CITY OF ALBUQUERQUE

RE: Fast Food Restaurant
Grading and Drainage Plan
Engineer's Stamp Date 2-27-2017 (File: B14D001)

Based upon the information provided in your submittal received 3-6-2017, the above referenced Grading and Drainage Plan cannot be approved for grading permit until the following comments are addressed:

GRADING AND DRAINAGE PLAN

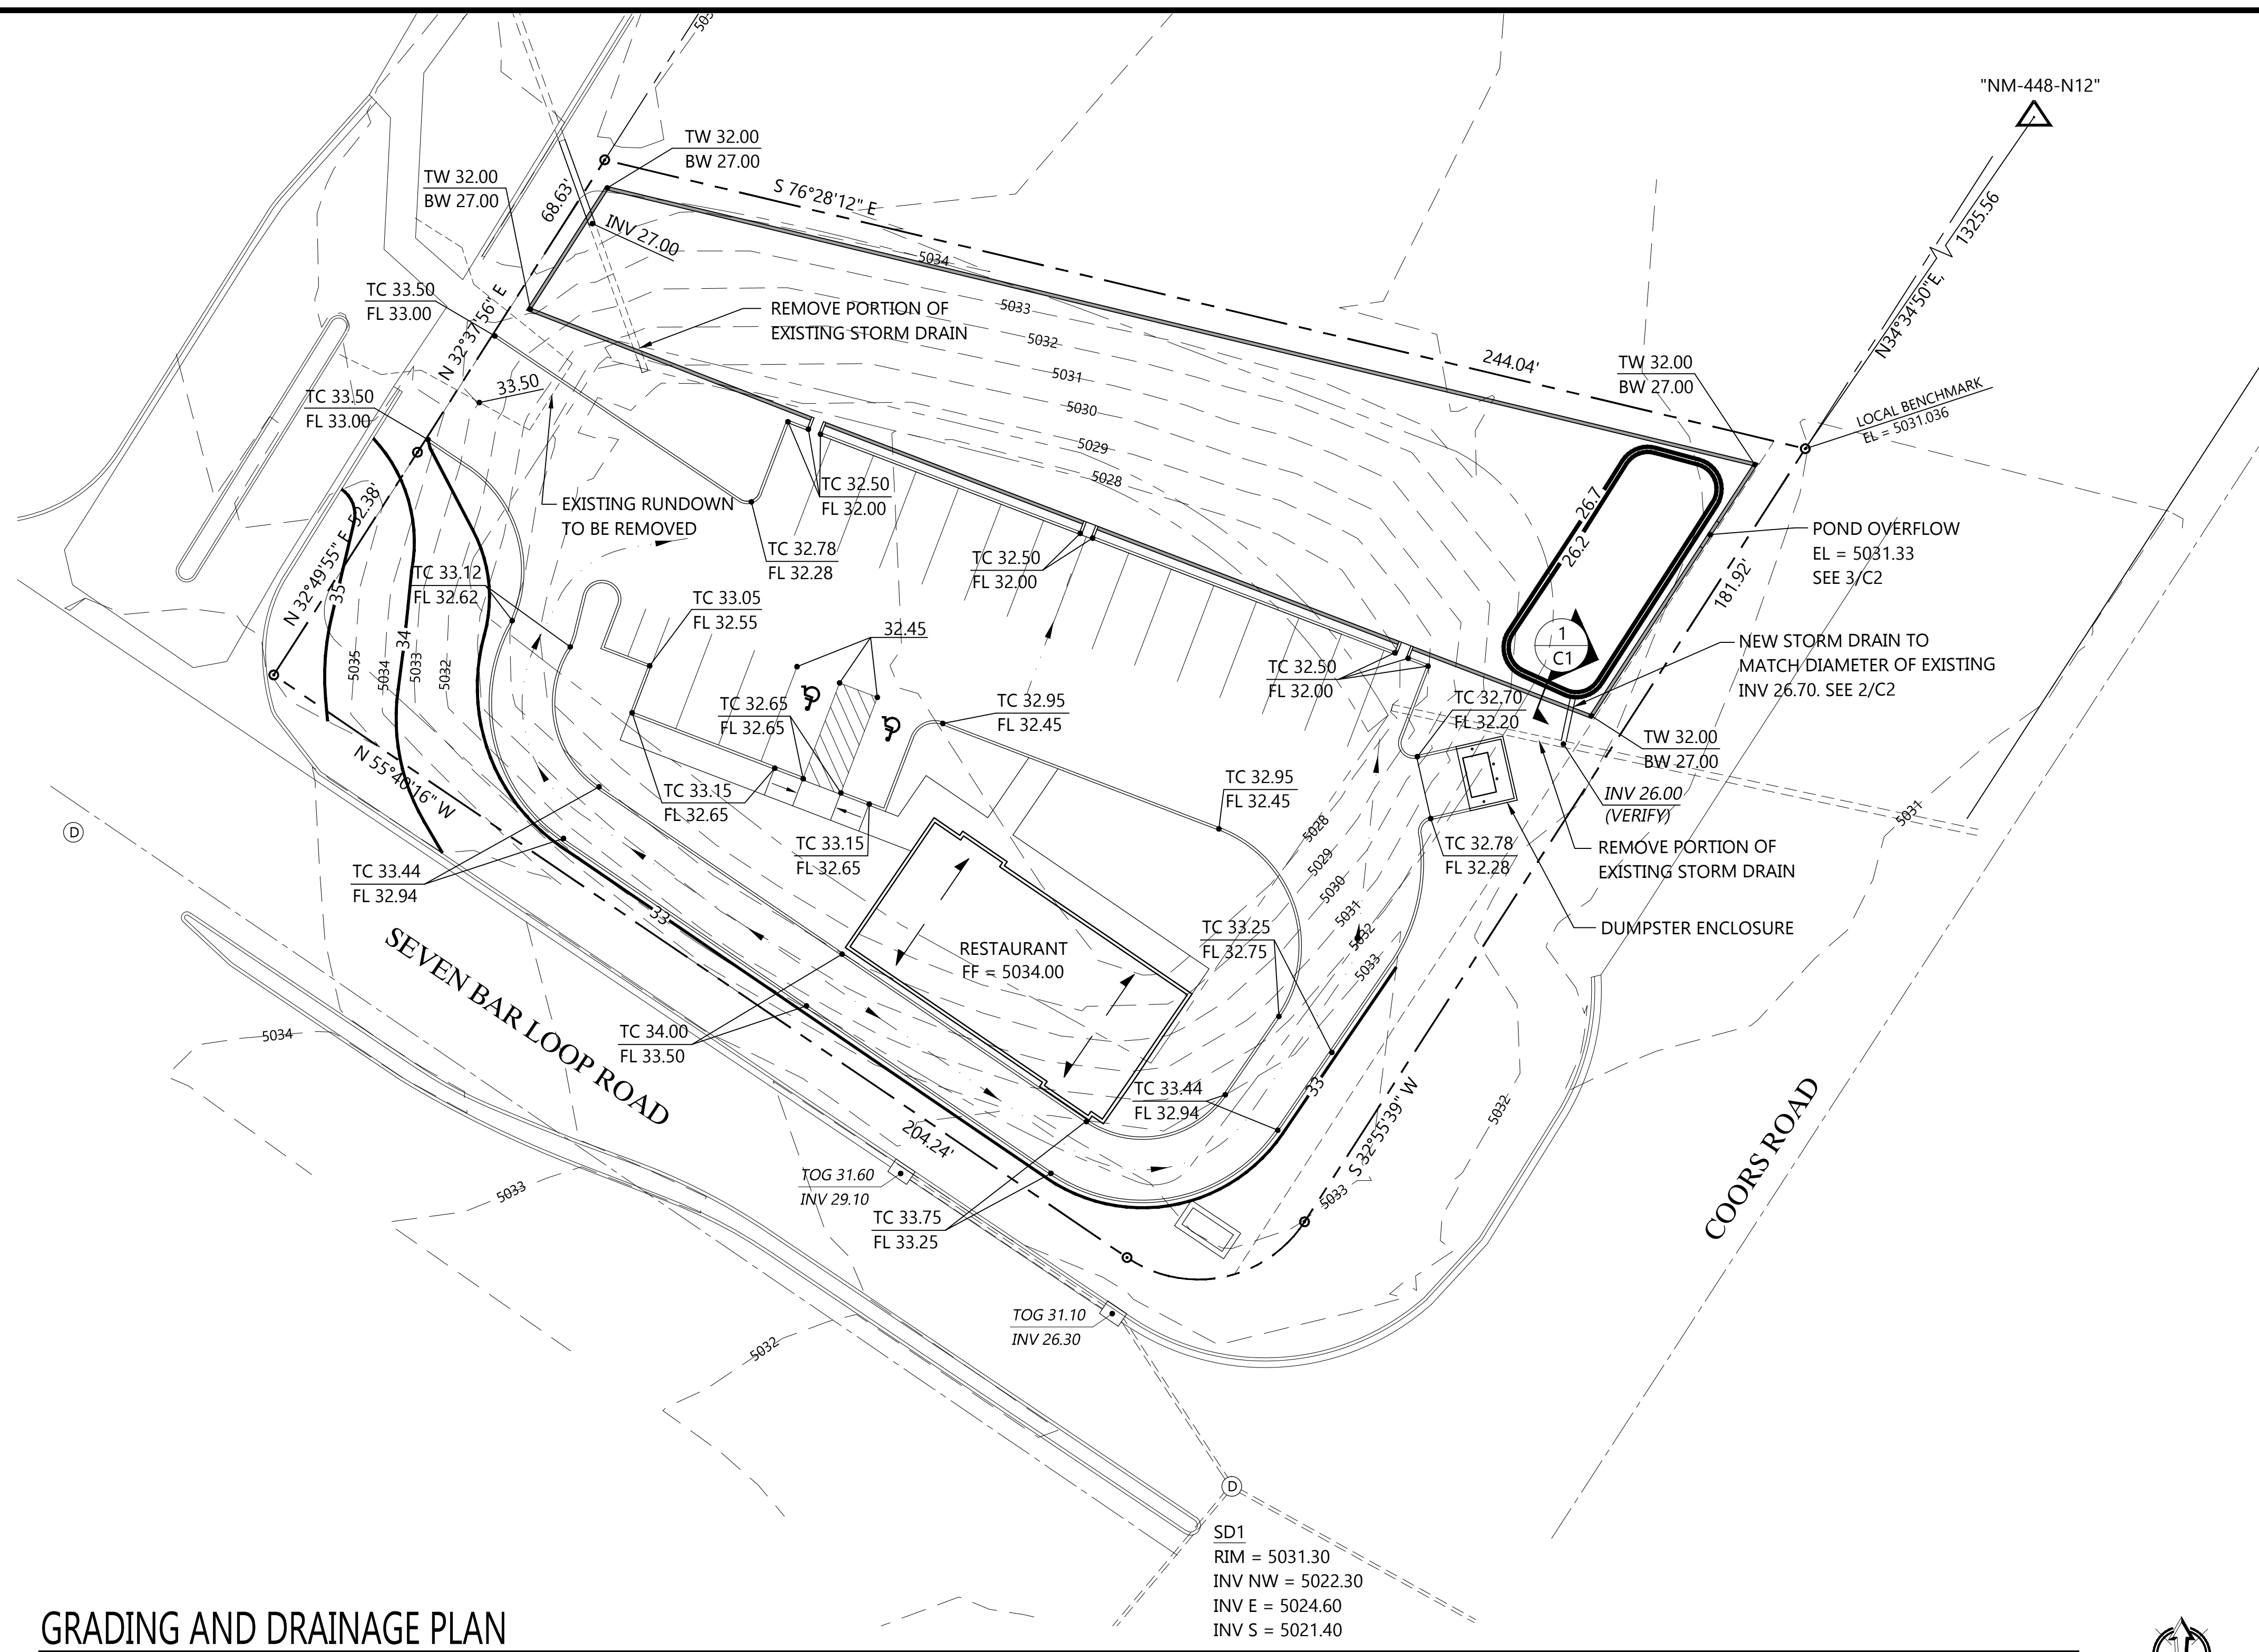
1. Provide details for the trash enclosure to ensure runoff will remain within the enclosure. Included a note that the drain must be connected to a Grease Trap then to the sewer system. Show the location of the Grease Trap and the inverts for the pipe.

2. Provide more details for the new storm drain pipe.
3. Provide roof drain location.
4. Provide more spot elevation along the curb and curb cut on the south side of the pond.

5. Provide more details on the pipe penetration through the wall. Are there any proposed rebar around the pipes?
6. Provide sidewalk grades if proposed / existing along Seven Bar Loop and Coors Road.

7. Provide size and inverts for the existing storm drain.
8. Not clear how proposed grading is being tied to existing grade along property line.
9. Where is the emergency over flow for the pond?

10. The area at elevation 26.5 and at elevation 27 is the same.
11. Invert for the outgoing pipe is shown at 27.00 on the plan but at 26.7 on calculations the runoff is being retained between 26.5 and 27.00 for the first flush ponding requirements.
